January 11, 2024

**RE: Golden Eagle, 99999 University Blvd. UPC: 101605026829920101**  
**A portion of Tract 18 Artiste, Mesa del Sol**  
**Conceptual Grading and Drainage Plan**  
**Engineer's Stamp Date: 1/10/2024**  
**Hydrology File: S17D001**

Based upon the information provided in your submittal received 1/11/2024, the Conceptual Grading & Drainage Plan is preliminary approved for Grading Permit and for action by the DHO/DFT for Platting and Site Plan actions.

C-00-G-10-02

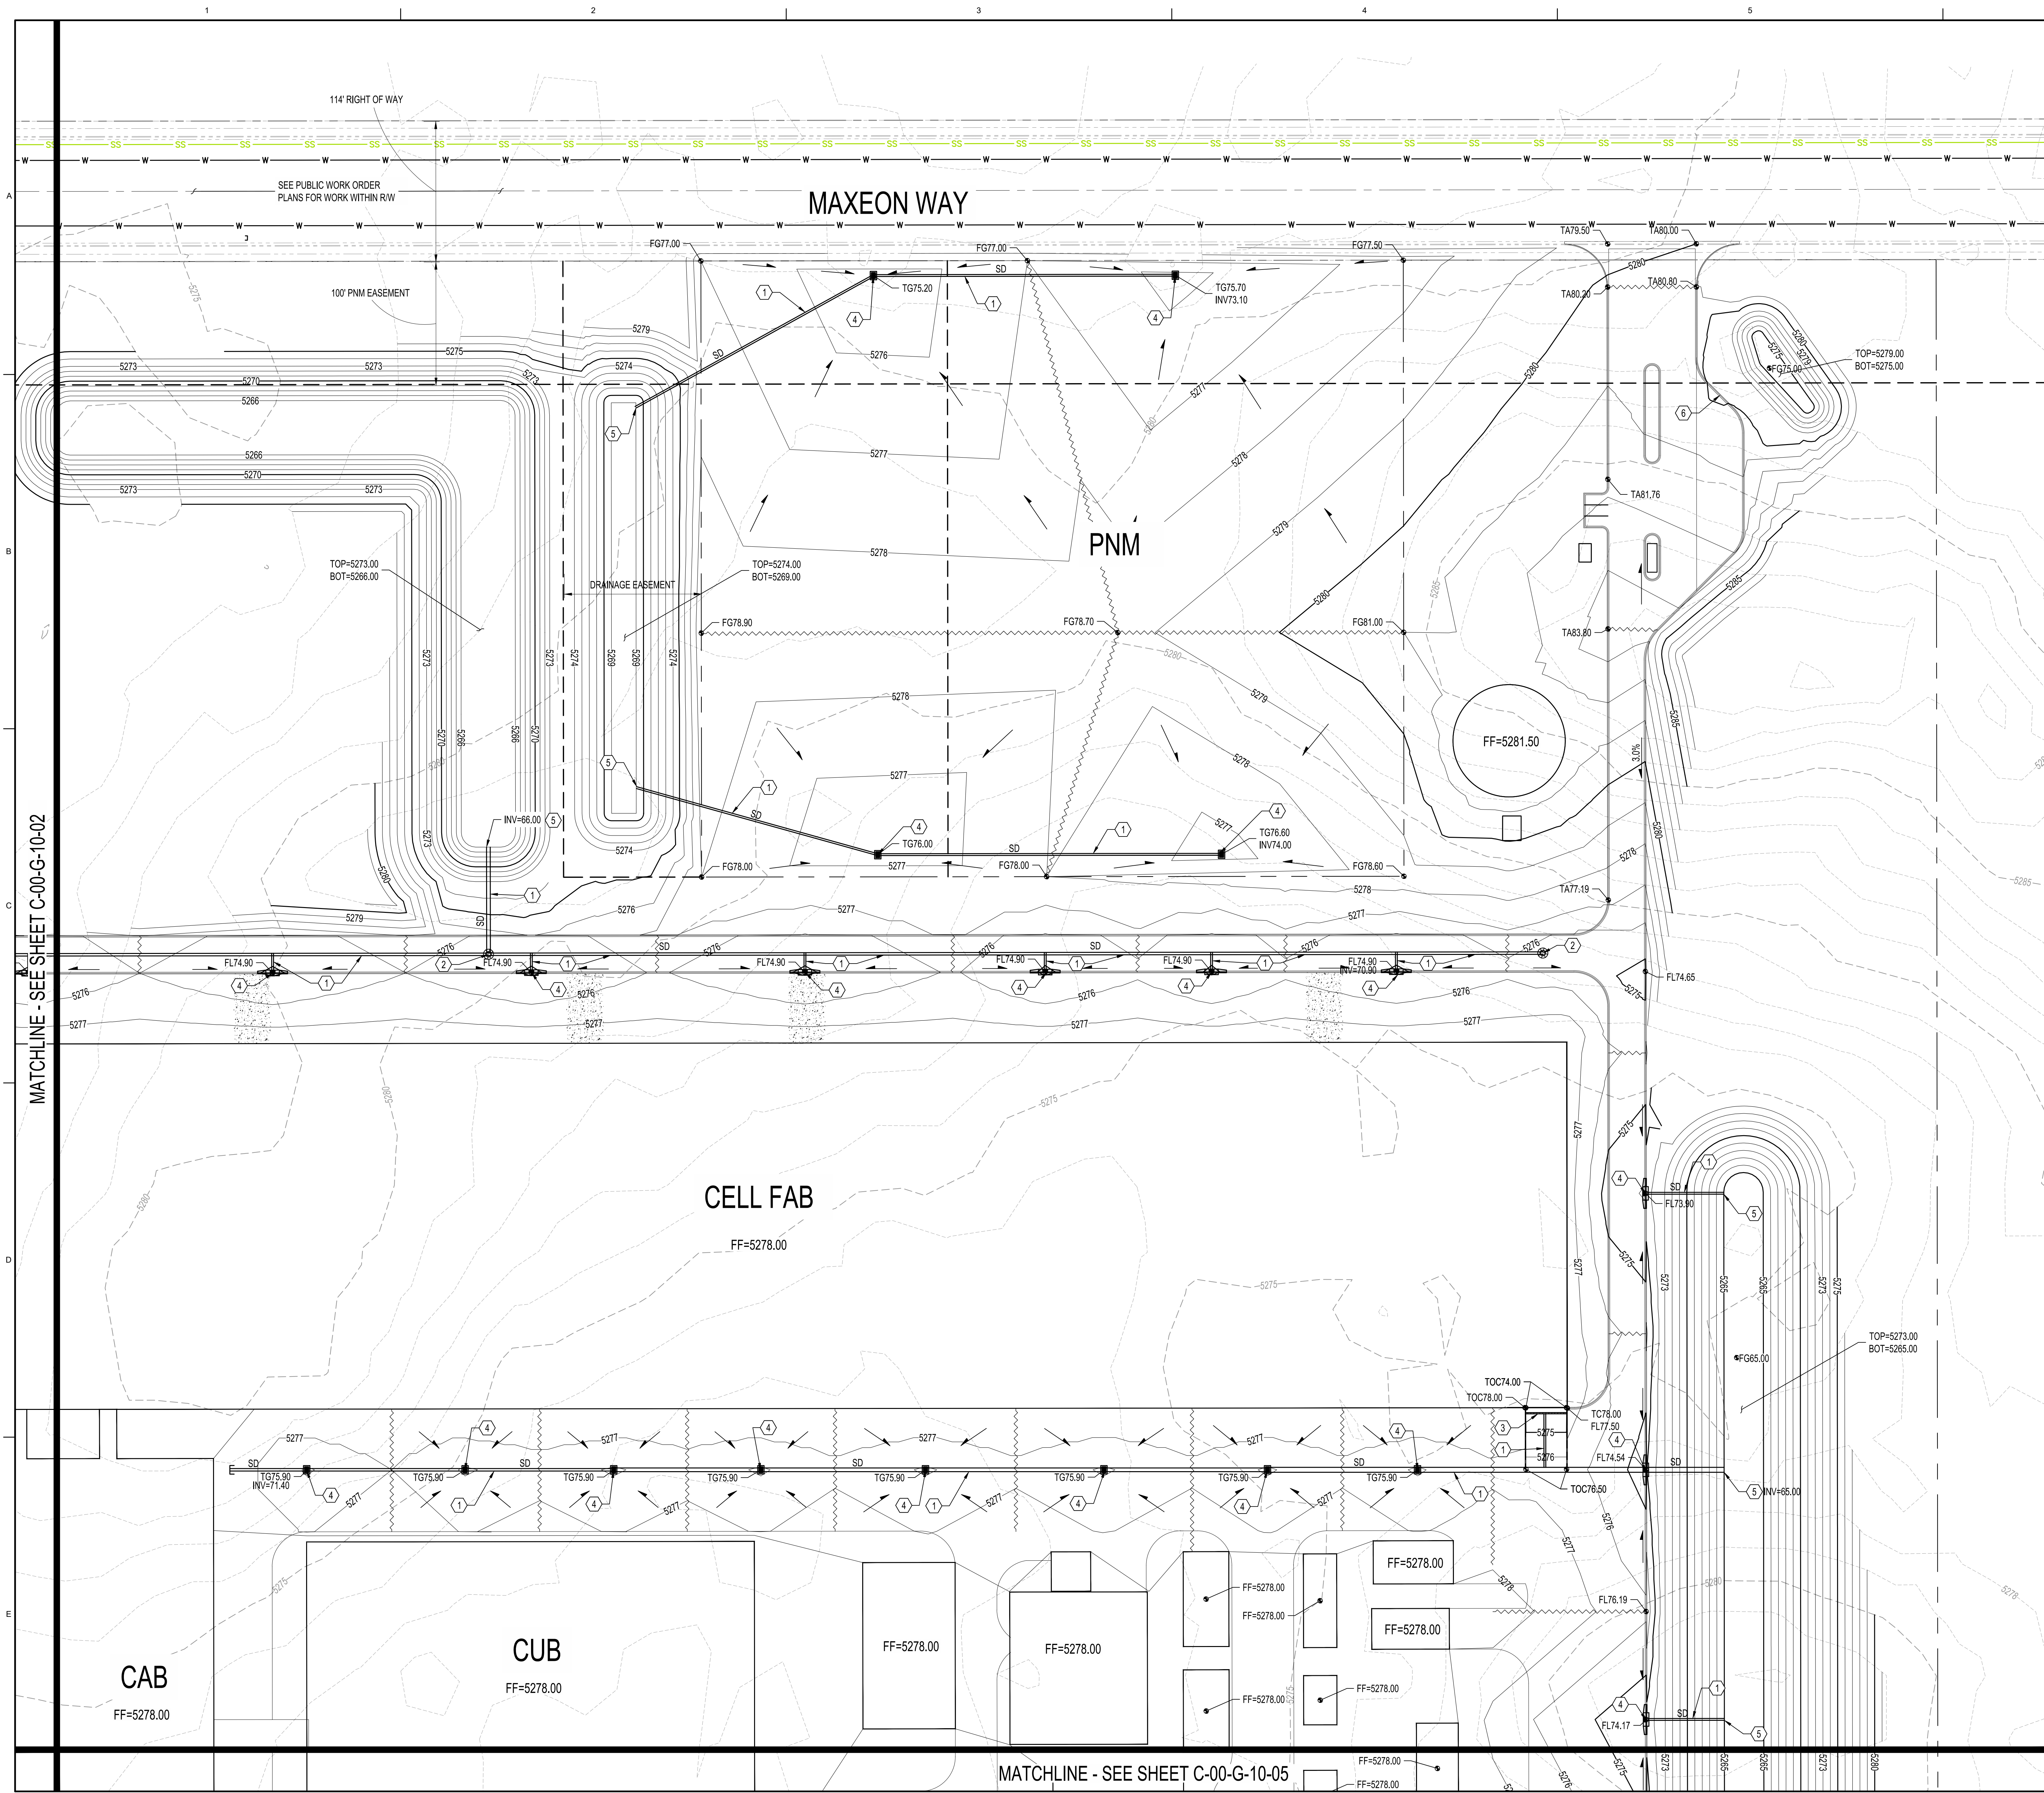
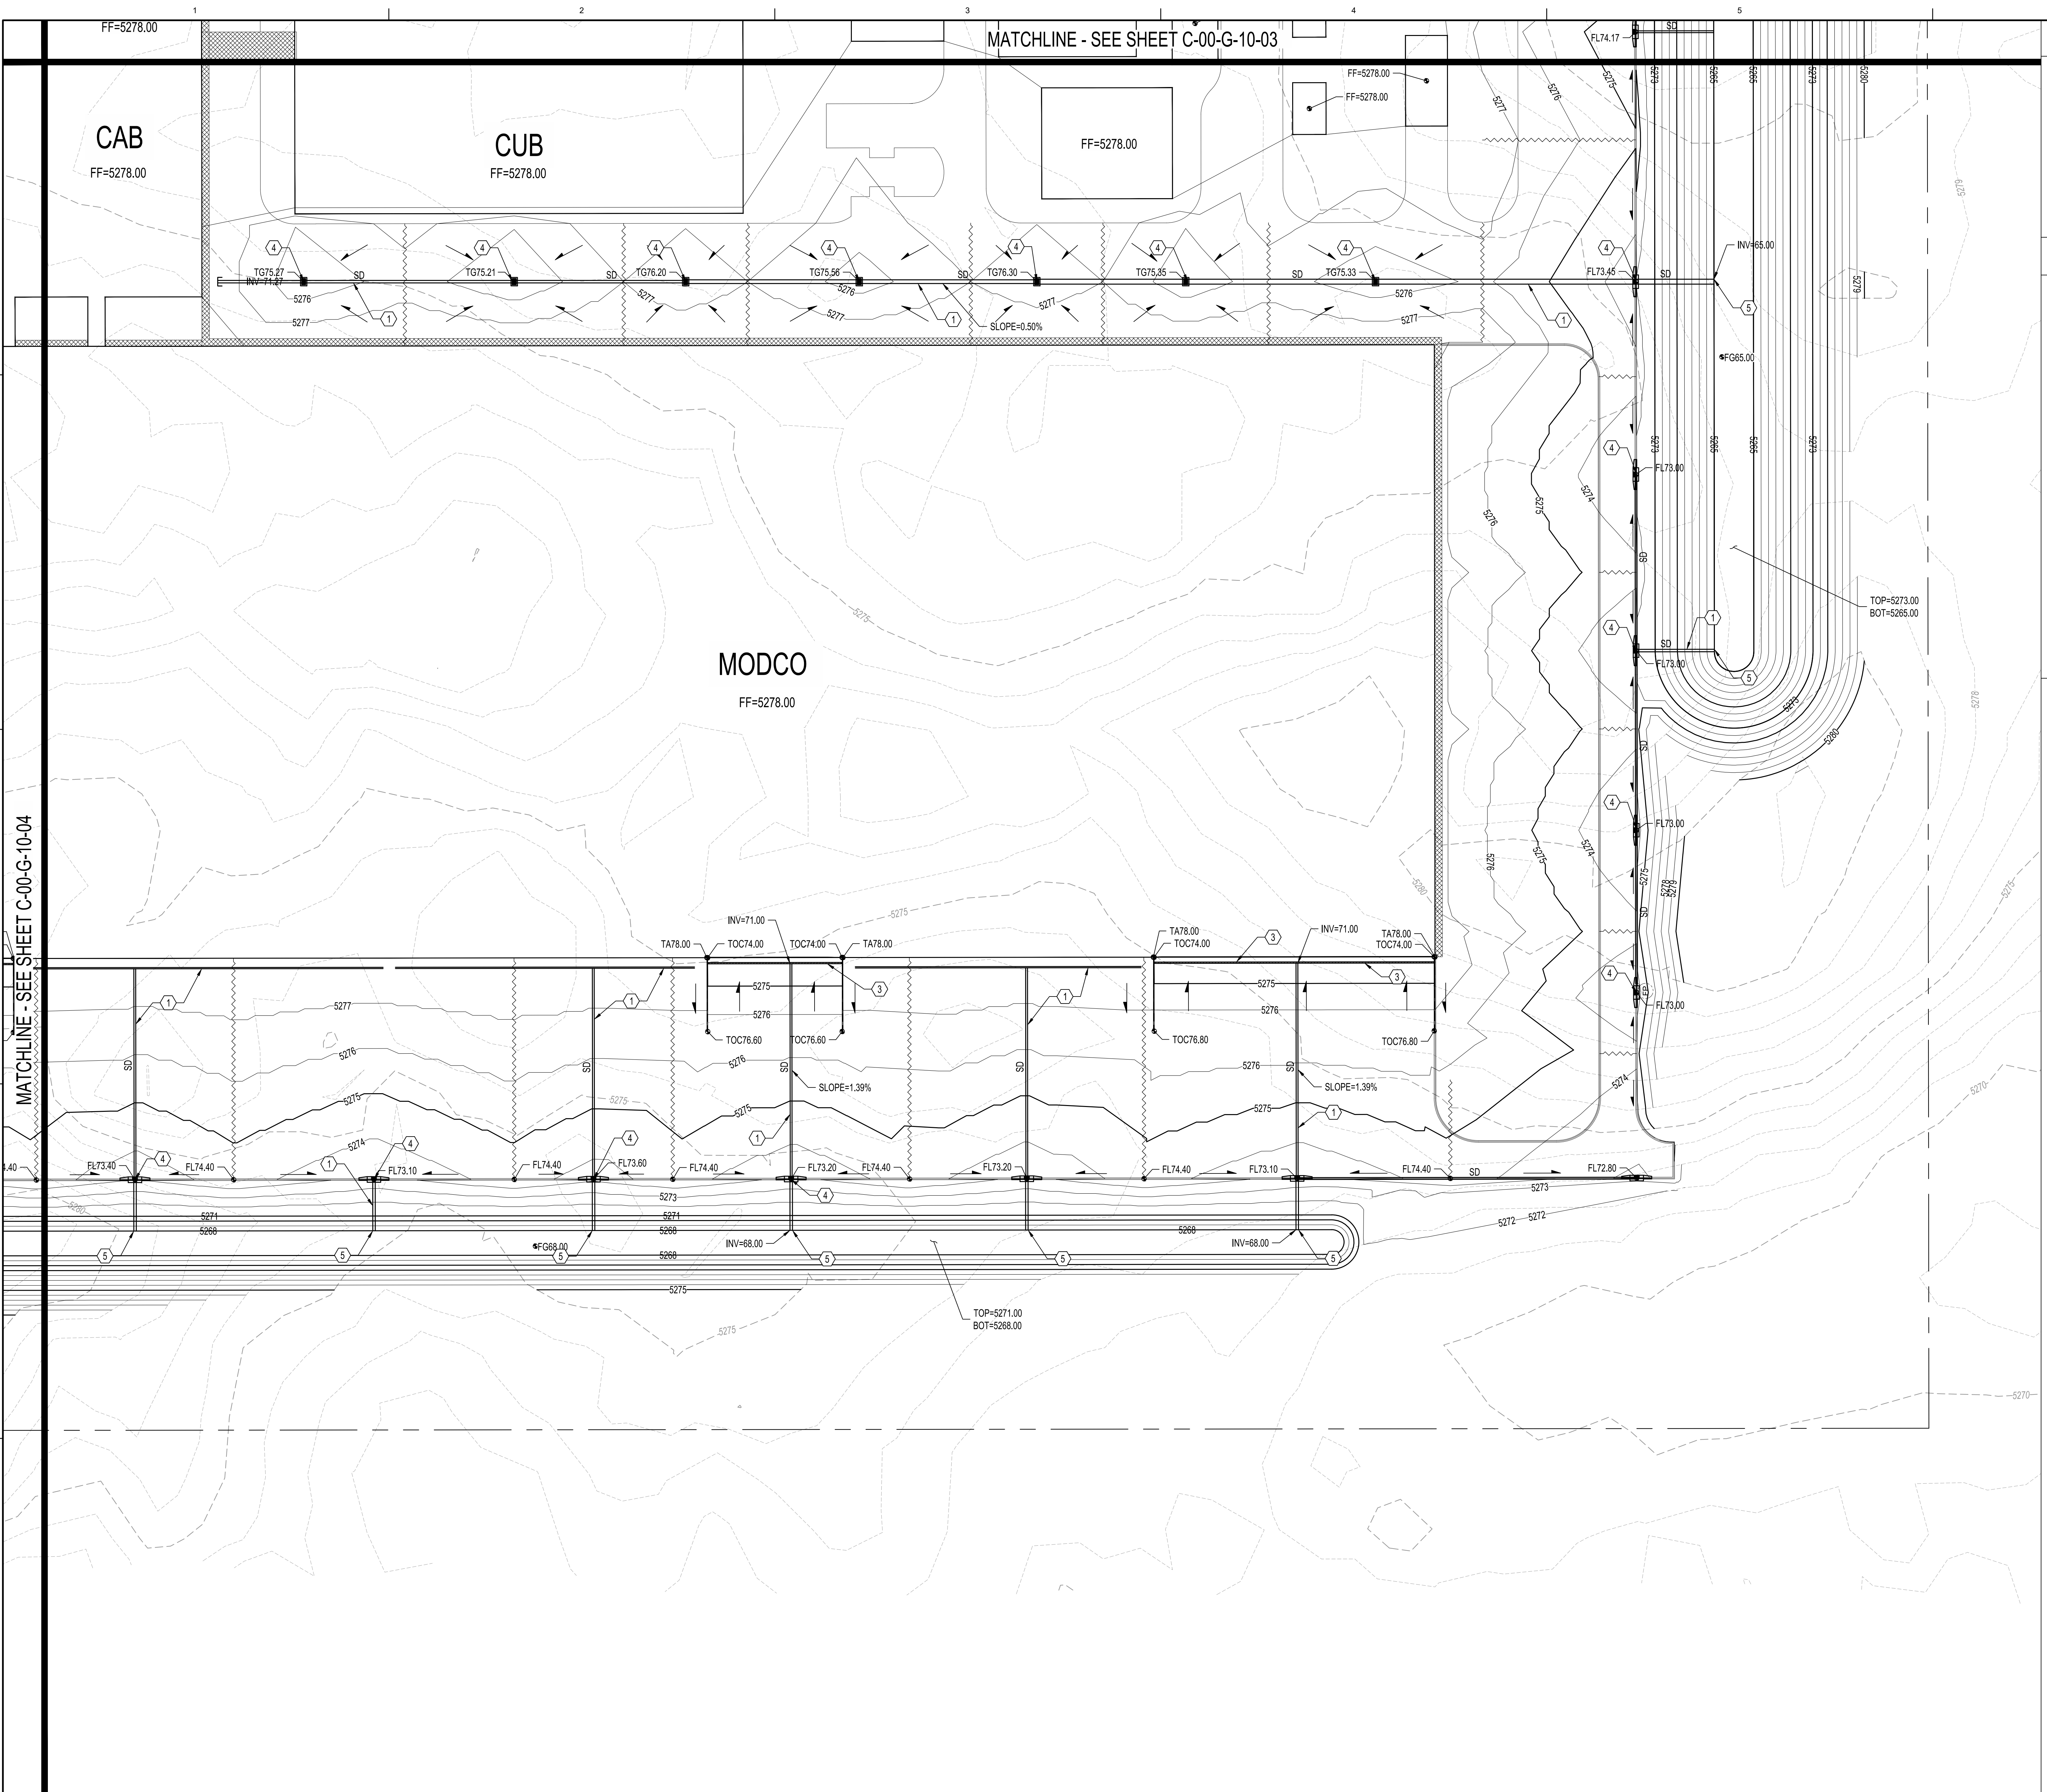
3. Add proposed SD pipe size on sheets C-00-G10-03 to C-00-G10-05.

4. Add proposed SD pipe size on the plan. **SD sizes have been added.**

DRAINAGE MANAGEMENT PLAN/WATER HARVESTING PLAN

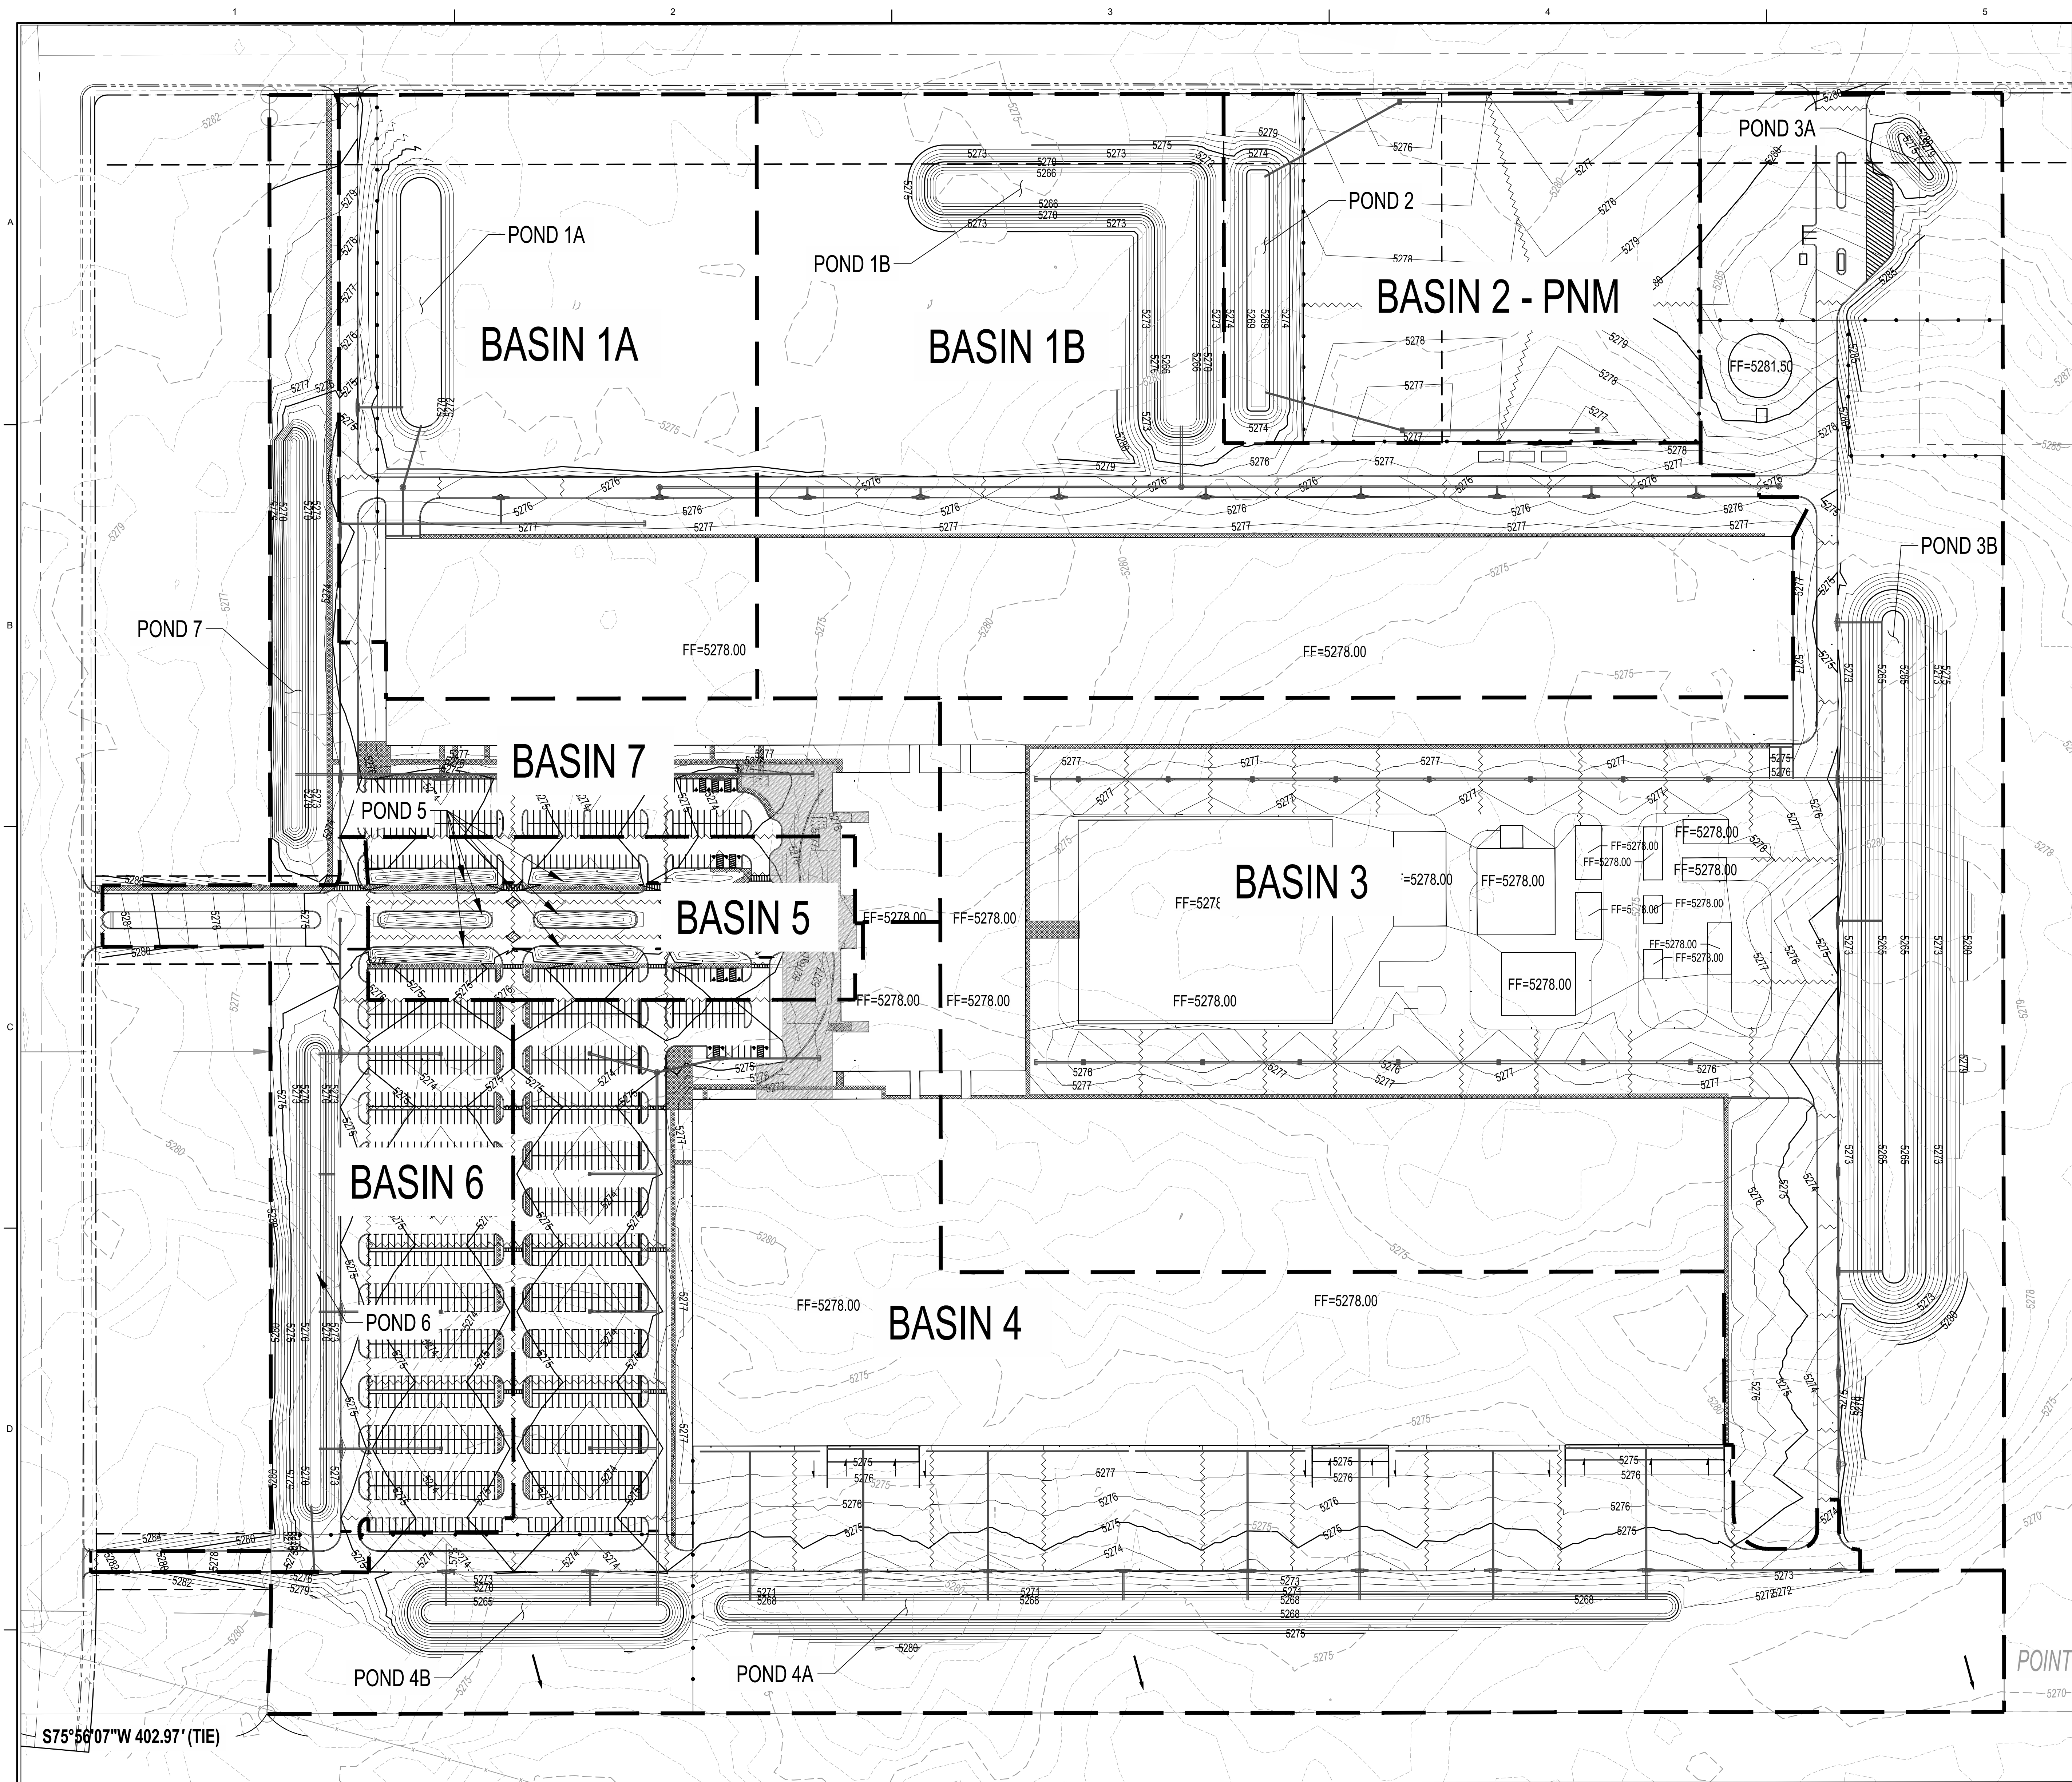
1. Please submit detailed Grading & Drainage Plan to Hydrology for review and approval.
2. Verify the provided volume for pond 5. It's smaller than the required volume.
